Response to ISH 1 with specific reference to North Leverton Windmill.

North Leverton Windmill Trust AND Fields for Farming

The proposed solar farm development is seen to harm the setting and significance of the windmill, a Grade II* listed heritage asset of national importance.

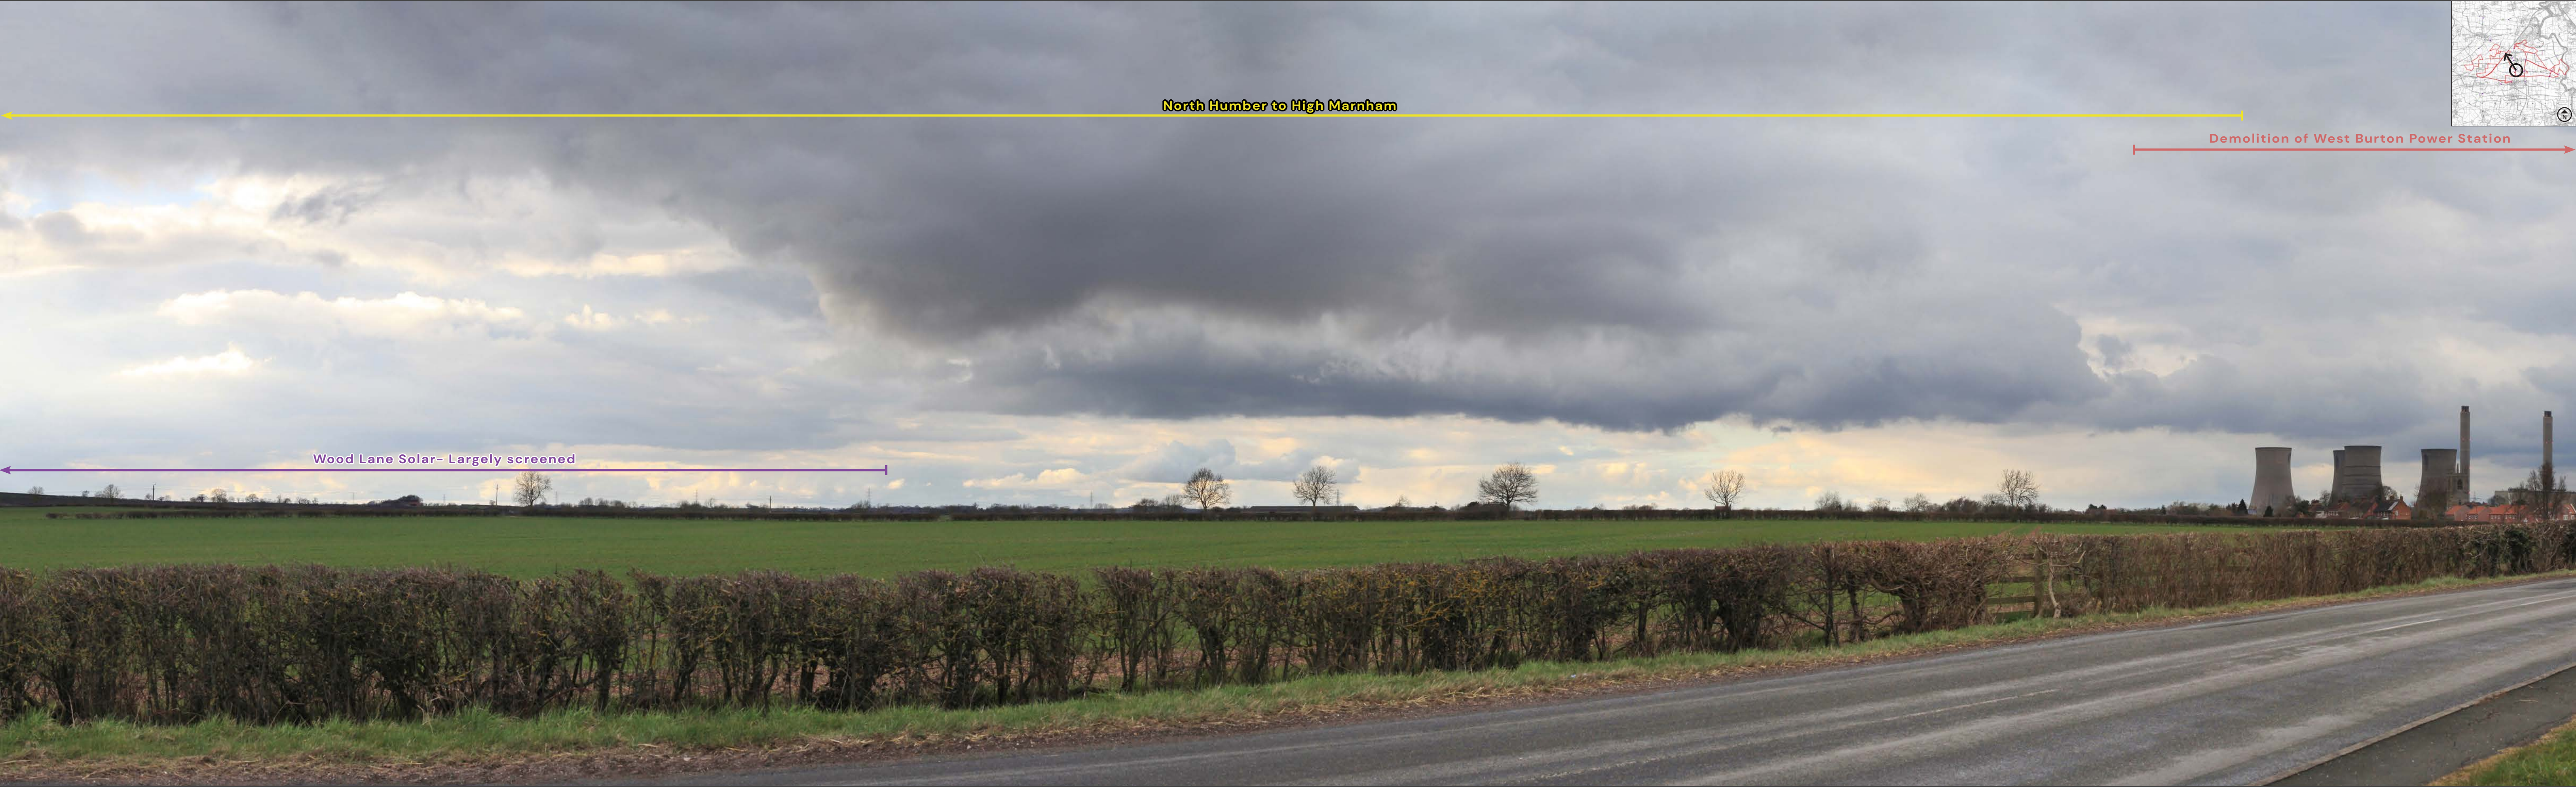
The applicant argued that there will be ample places to view the windmill, its setting and landscape, however we fail to see how this will be possible with 3m high solar panels from Year 1 and/or 3m mitigation screening at Year 15 looking towards the windmill from within the proposed development area, and a backdrop of solar panels when looking from Retford

Road and other vantage points towards the Windmill. The proposed mitigation are both well above the height of the average person and, knowing these roads and footpaths very well, we fail to comprehend where these ample views will be. (Referring to EN010163-000085-6.3.6 Appendix 6.2 Photomontages Part 2 - Winter.pdf. and specifically, Viewpoint 12 as an example of the impact of solar panels and screening.
